## EL PASO COUNTY GRADING AND EROSION CONTROL PLAN CHECKLIST

EPC Project Number: SF2315

SHEET NO.:
GEC-1

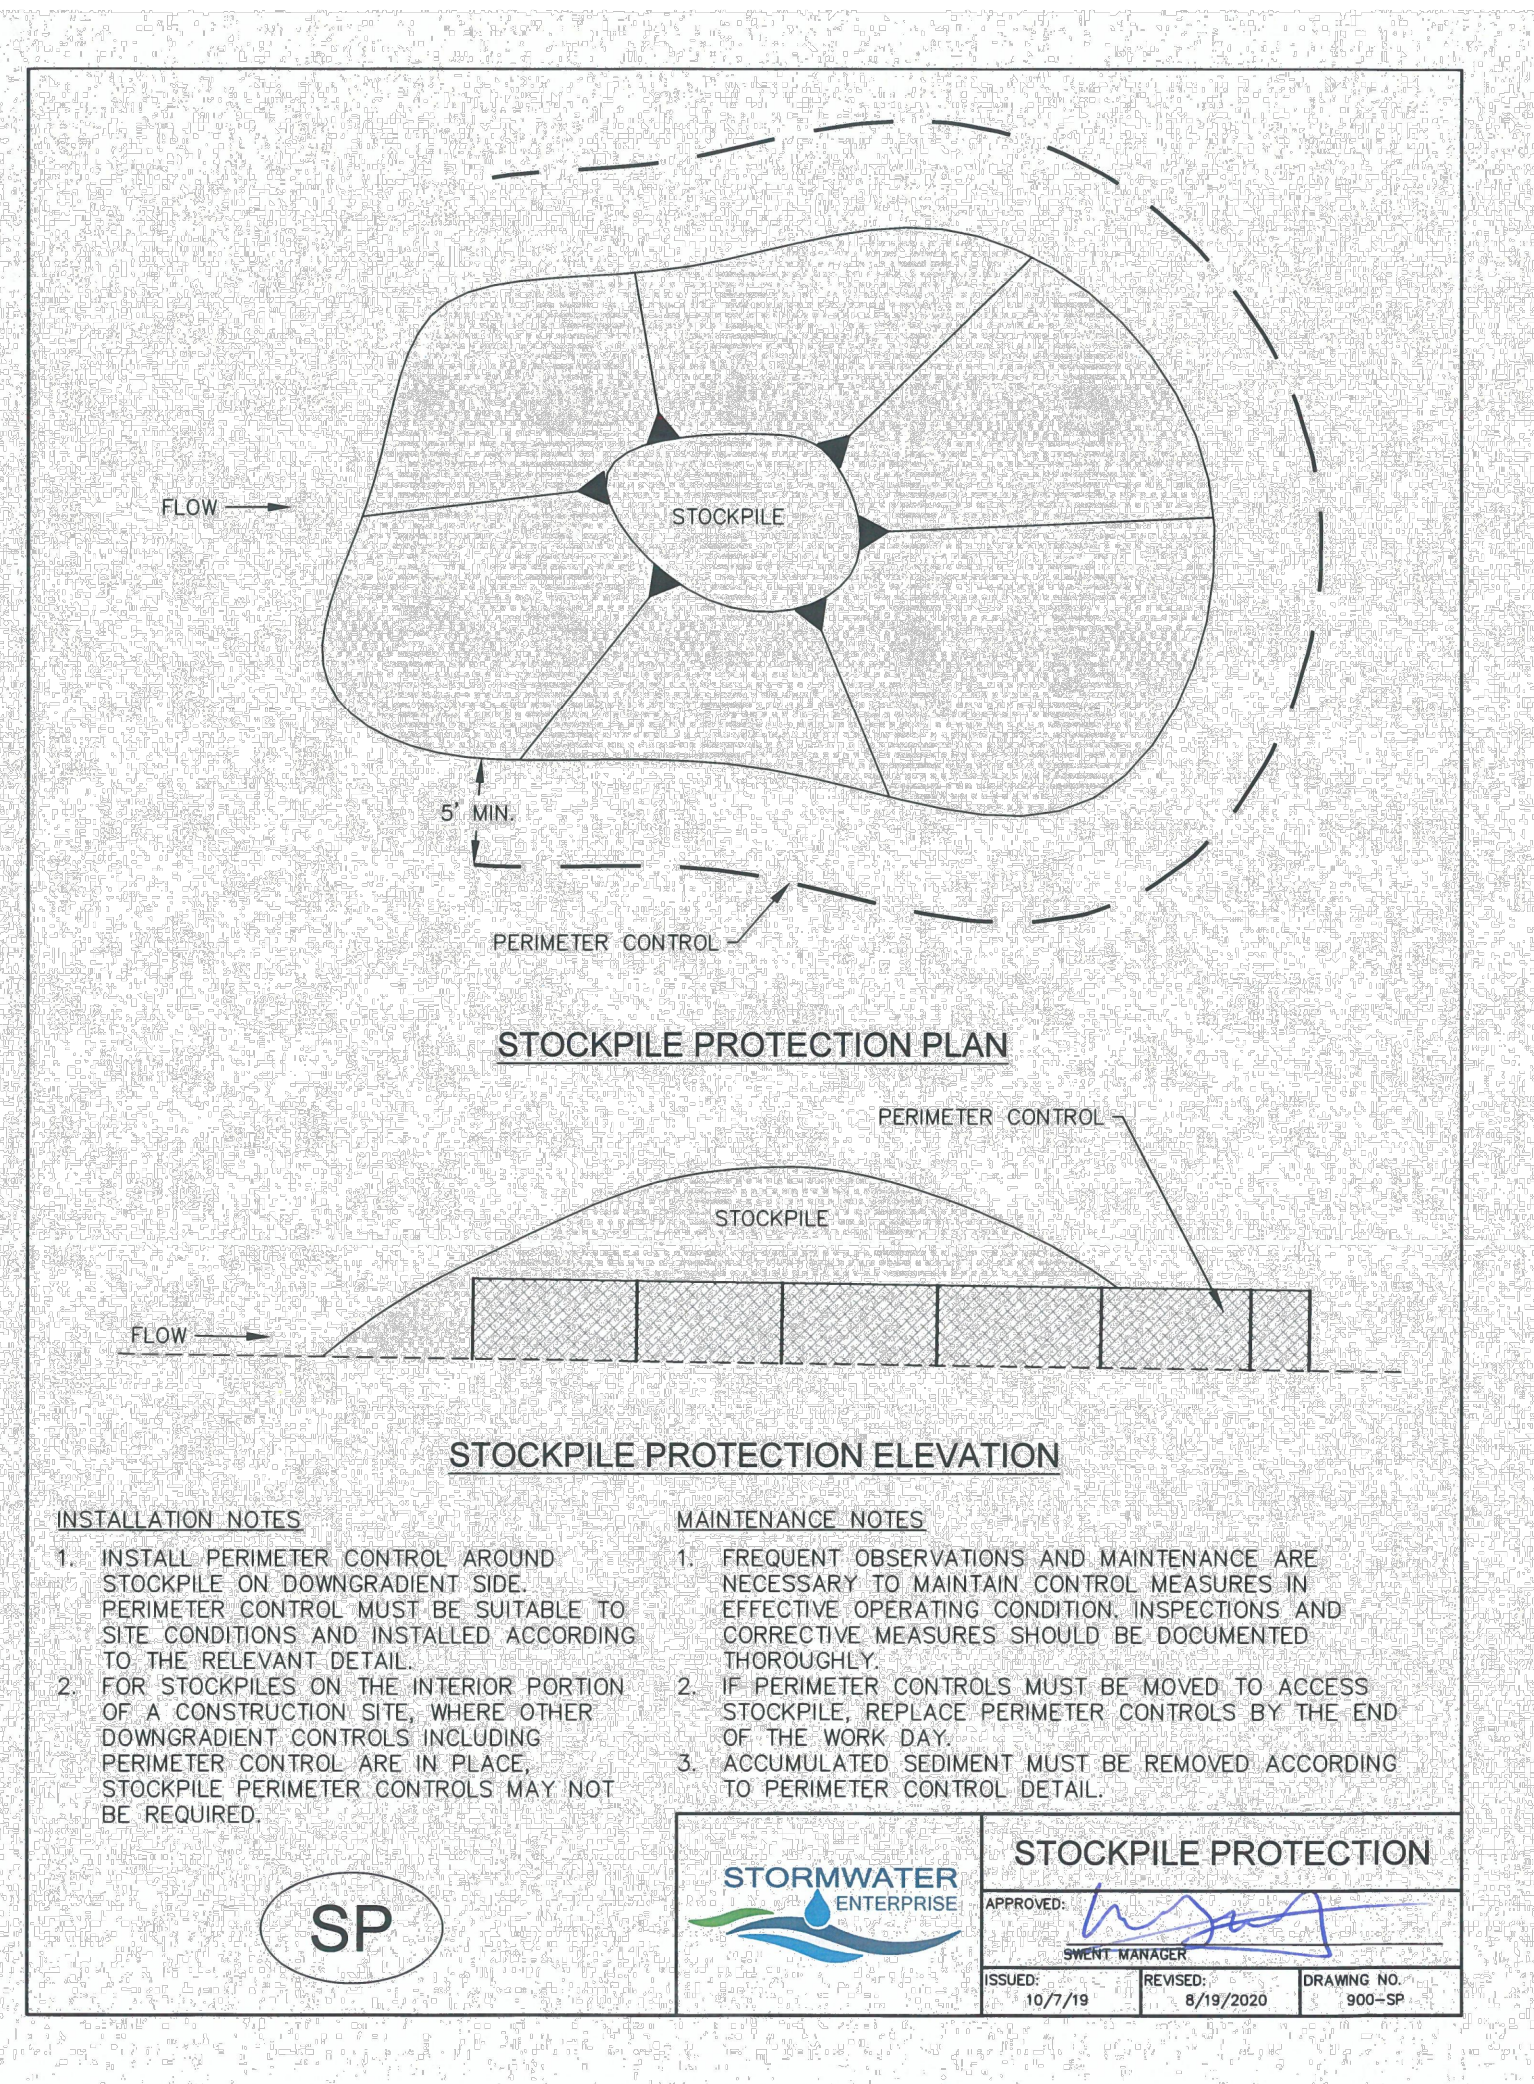
Applicant	EPC
<b>1. GRADING AND EROSION CONTROL PLAN</b> (complete form using Y, N, N/A in the "Applicant" column)			
a	Vicinity map		Y
b	Adjacent city/town/jurisdictional boundaries, subdivision names, and property parcel numbers labeled		Y
c	North arrow and acceptable scale (1"=20' to 1"=100')		Y
d	Legend for all symbols used in the plan		Y
e	Existing and proposed property lines. Proposed subdivision boundary for subdivision projects		Y
f	All existing structures		Y
g	All existing utilities		Y
h	Construction site boundaries		Y
i	Existing vegetation (notes are acceptable in cases where there is no notable vegetation, only grasses/weeds, or site has already been stripped)		Y
j	FEMA 100-yr floodplain		N/A
k	Existing and proposed water courses including springs, streams, wetlands, detention ponds, stormwater quality structures, roadside ditches, irrigation ditches and other water surfaces. Show maintenance of pre-existing vegetation within 50 feet of a receiving water <span style="border: 1px solid black; padding: 2px;">Show RPA areas.</span>

l	Existing and proposed contours 2 feet or less (except for hillside) <span style="border: 1px solid black; padding: 2px; color: red;">Unresolved - dothartford 08/24/2023 2:43:03 PM</span>		Y
m	Limits of disturbance delineating all anticipated areas of soil disturbance		Y
n	Identify and protect areas outside of the construction site boundary with existing fencing, construction fencing or other methods as appropriate		Y
o	Off-site grading clearly shown and called out		N/A
p	Areas of cut and fill identified		Y
q	Conclusions from soils/geotechnical report and geologic hazards report incorporated in grading design (slopes, embankments, materials, mitigation, etc.)		Y
r	Proposed slopes steeper than 3:1 with top and toe of slope delineated. Erosion control blanketing or other protective covering required		N/A
s	Stormwater flow direction arrows		Y
t	Location of any dedicated asphalt / concrete batch plants		N/A

u	Areas used for staging, storage of building materials, soils (stockpiles) or wastes. The use of construction office trailers requires PCD permitting		Y
v	All proposed temporary construction control measures, structural and non-structural. Temporary construction control measures shall be identified by phase of implementation to include "initial," "interim," and "final" or shown on separate phased maps identifying each phase		Y
w	Vehicle tracking provided at all construction entrances/exits. Construction fencing, barricades, and/or signage provided at access points not to be used for construction		Y
x	Temporary sediment ponds provided for disturbed drainage areas greater than 1 acre		N

SHEET NO.:
GEC-2

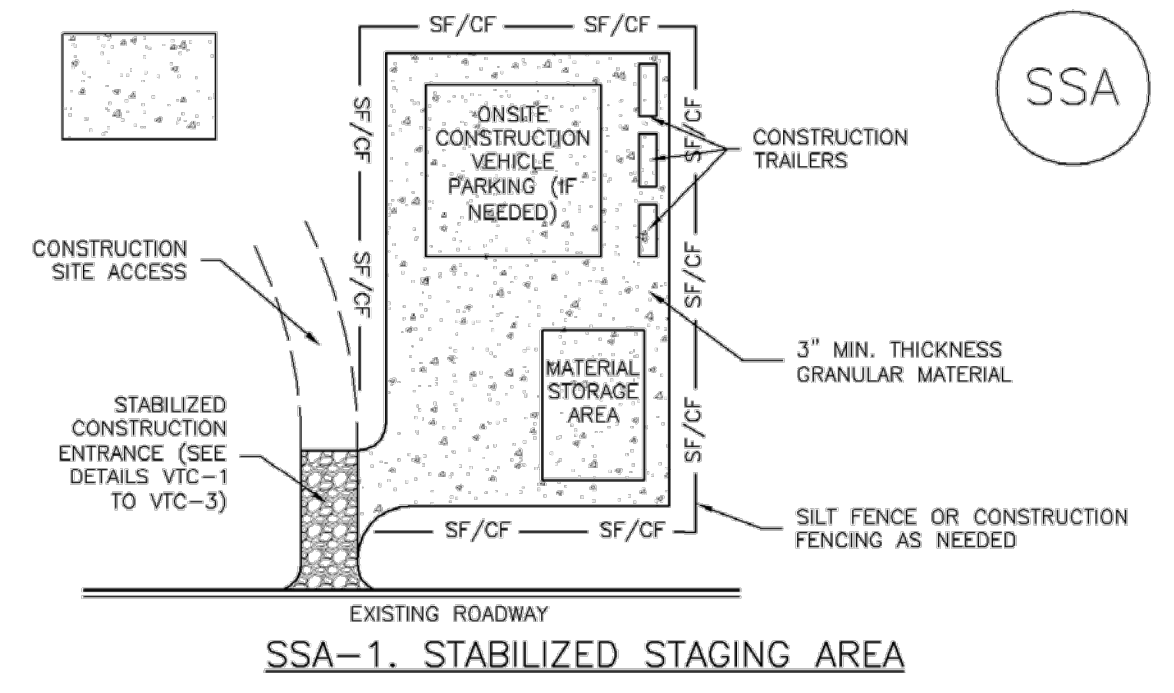
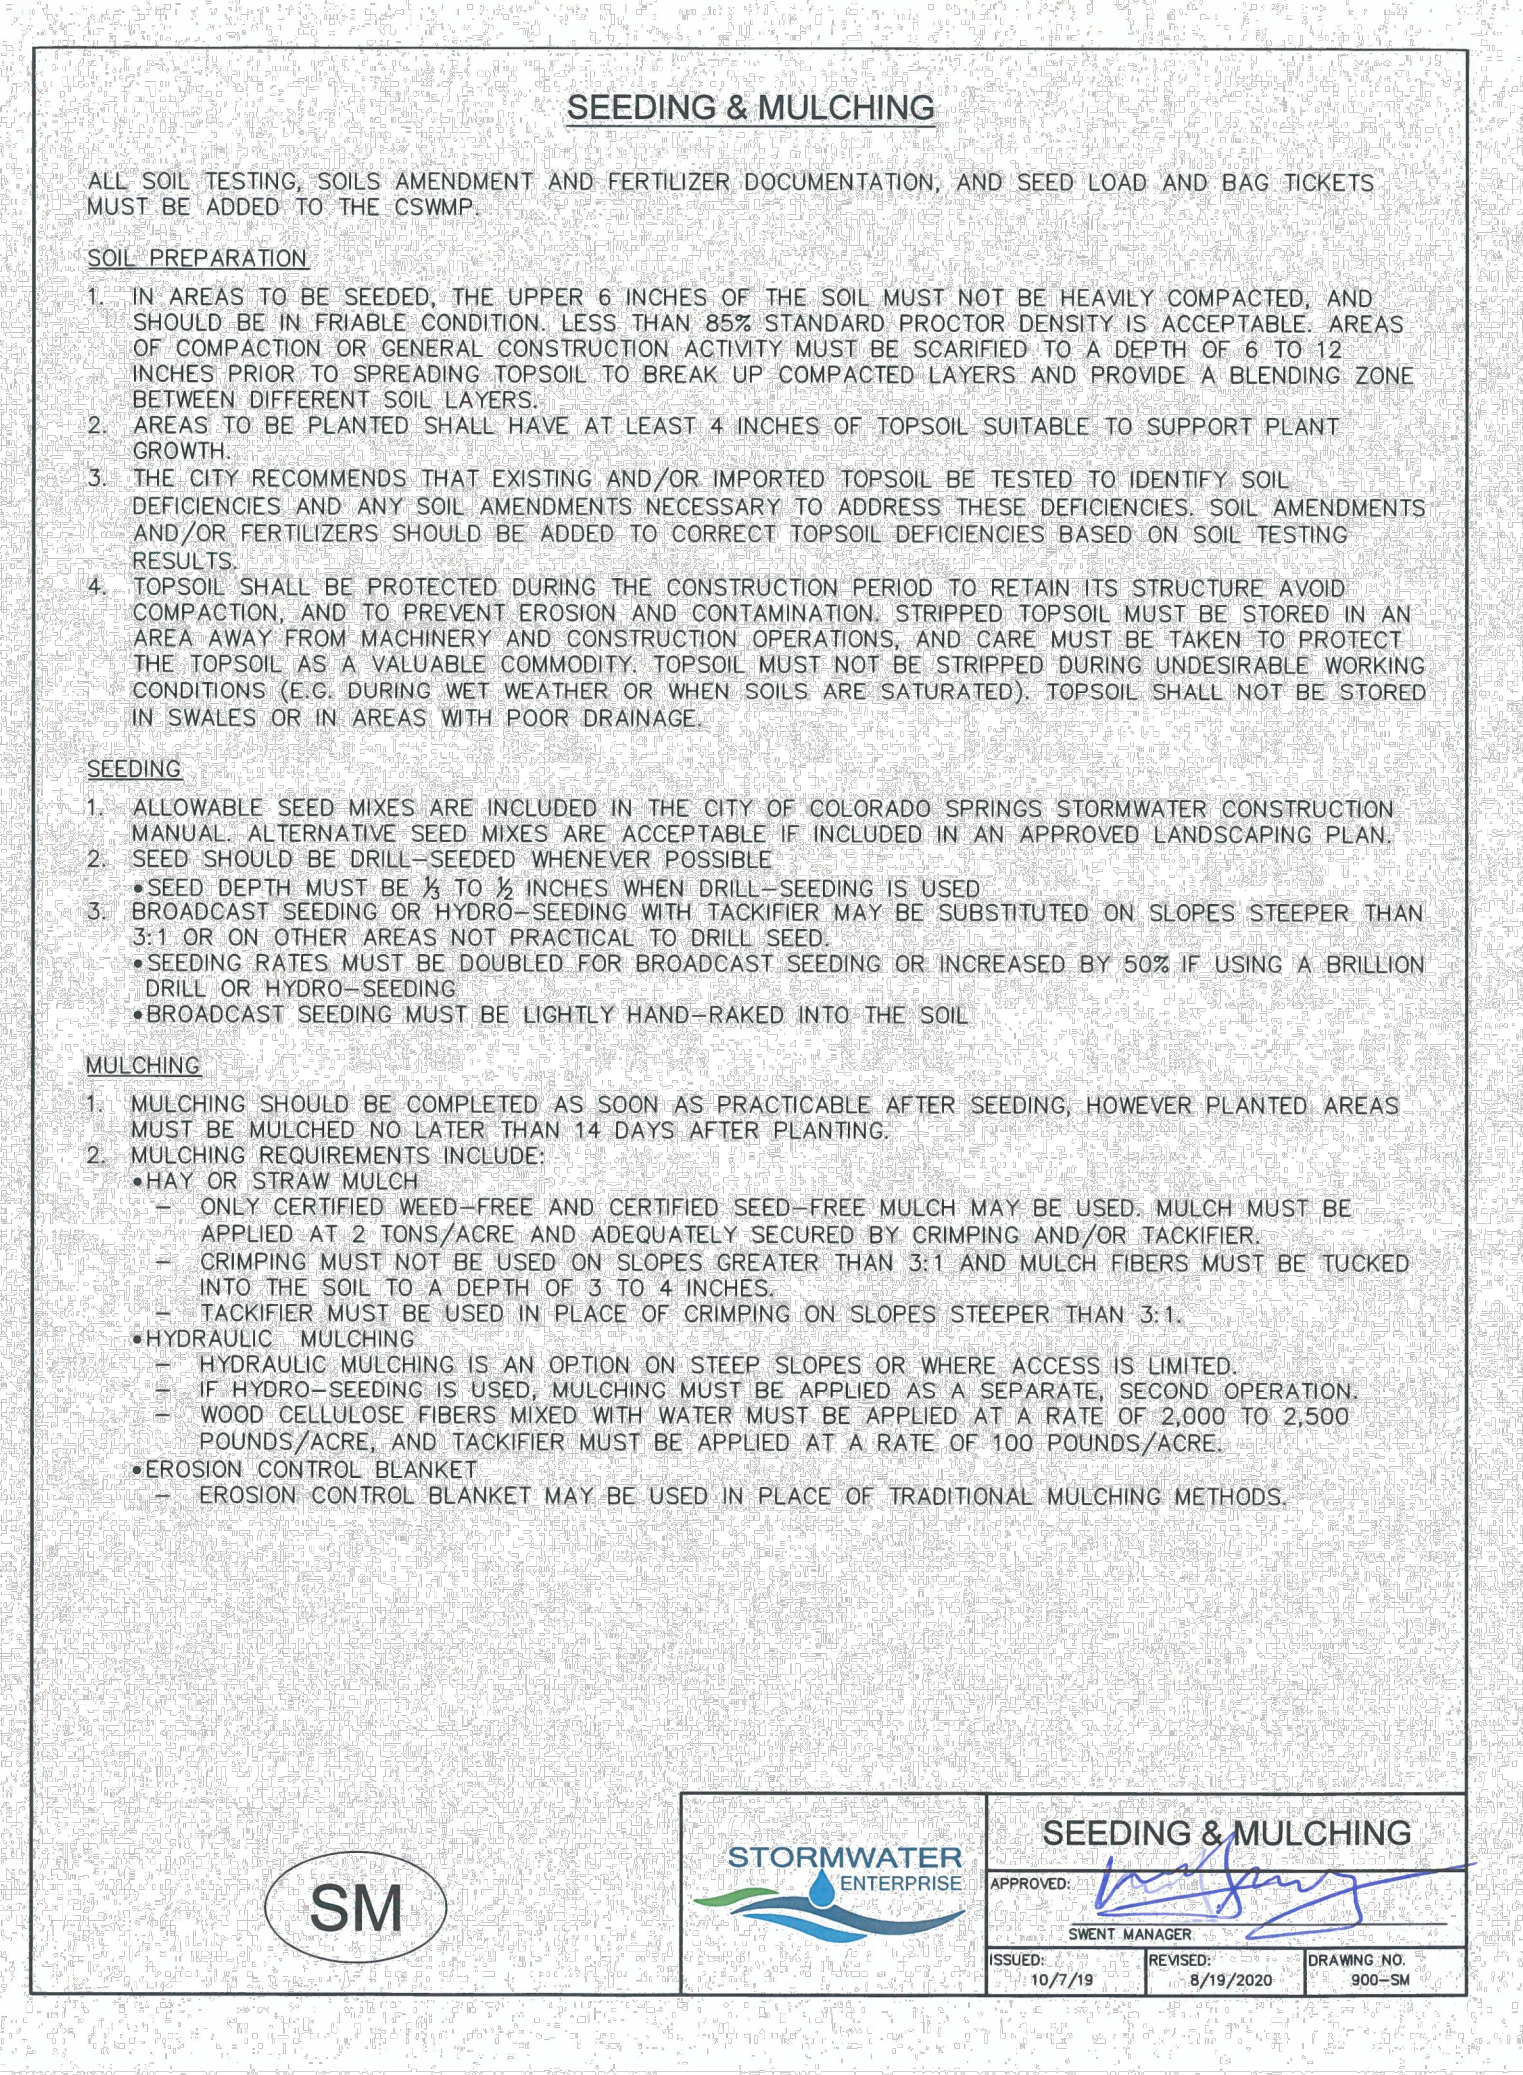
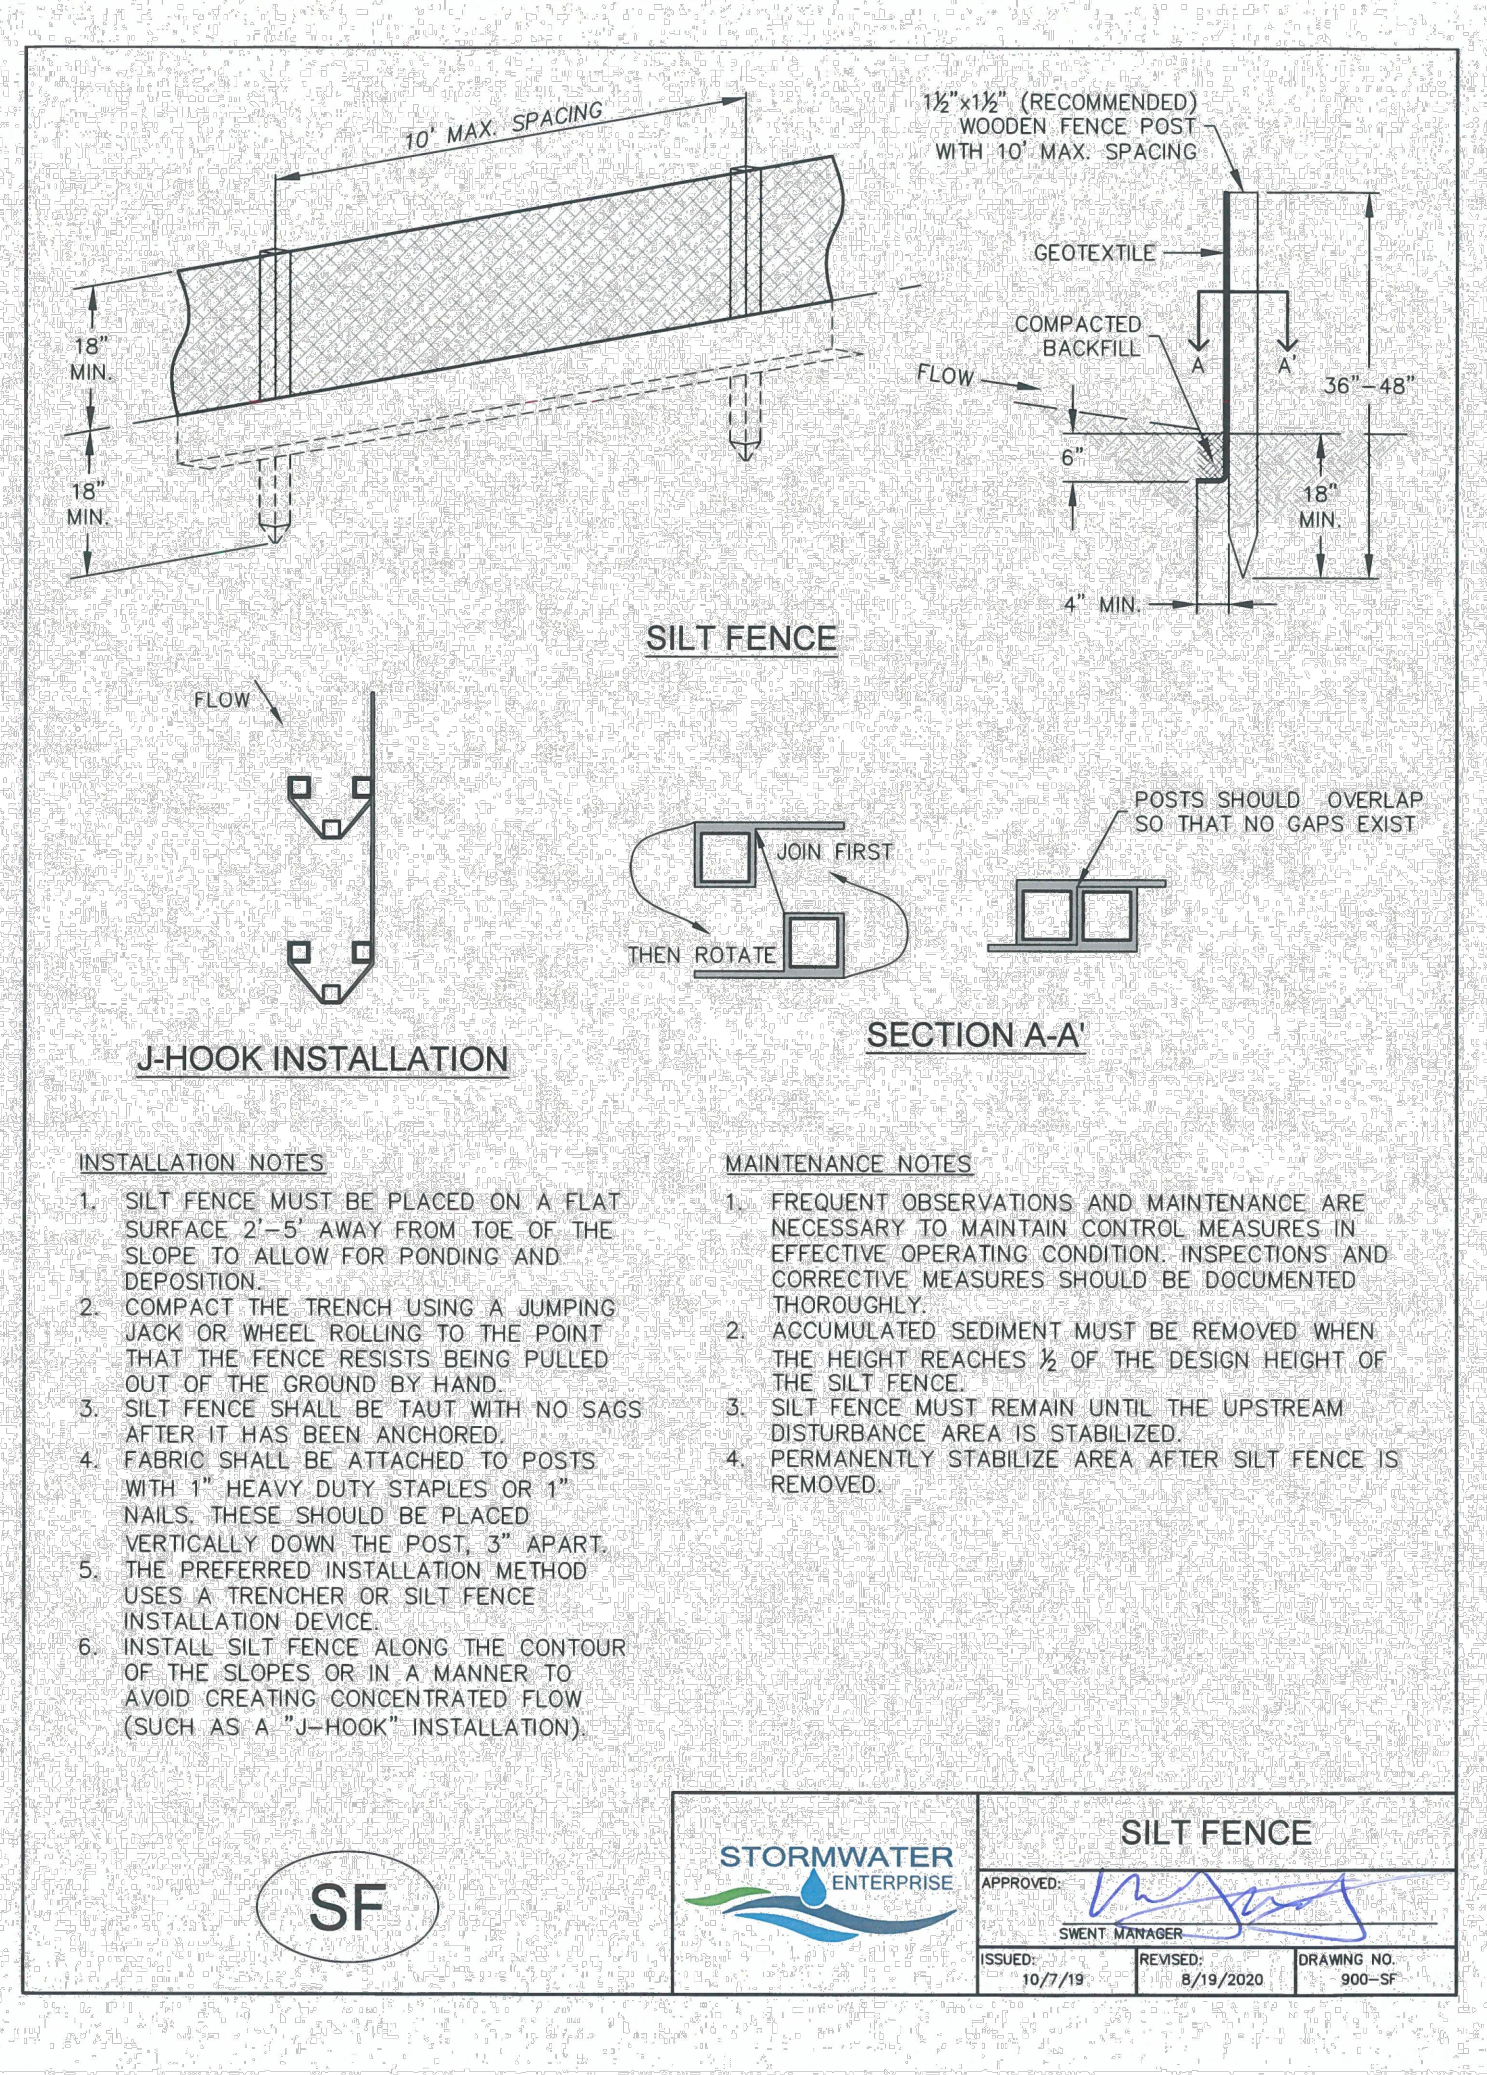
Applicant	EPC
y	Dewatering operations to include locations of diversion, pump and discharge(s) as anticipated at time of design		N/A
z	All proposed temporary construction control measure details. <u>Custom or other jurisdiction's details used must meet or exceed EPC standards</u> <u>see comment on Sht GEC-3</u>	Unresolved - dothartford 08/24/2023 2:43:12 PM	
aa	Any off-site stormwater control measure proposed for use by the project and not under the direct control or ownership of the Owner or Operator		N/A
bb	Existing and proposed permanent storm water management facilities, including areas proposed for stormwater infiltration or subsurface detention <u>Show RPA areas for runoff reduction</u>	Unresolved - dothartford 08/24/2023 2:43:14 PM	
cc	Existing and proposed easements (permanent and construction) including required off-site easements		Y
dd	Retaining walls shall not to be located in County ROW unless approved via license agreement. A building permit from Regional Building Department is required for walls greater than or equal to 4 feet in height, series of walls, or walls supporting a surcharge and must be design by P.E.		N/A
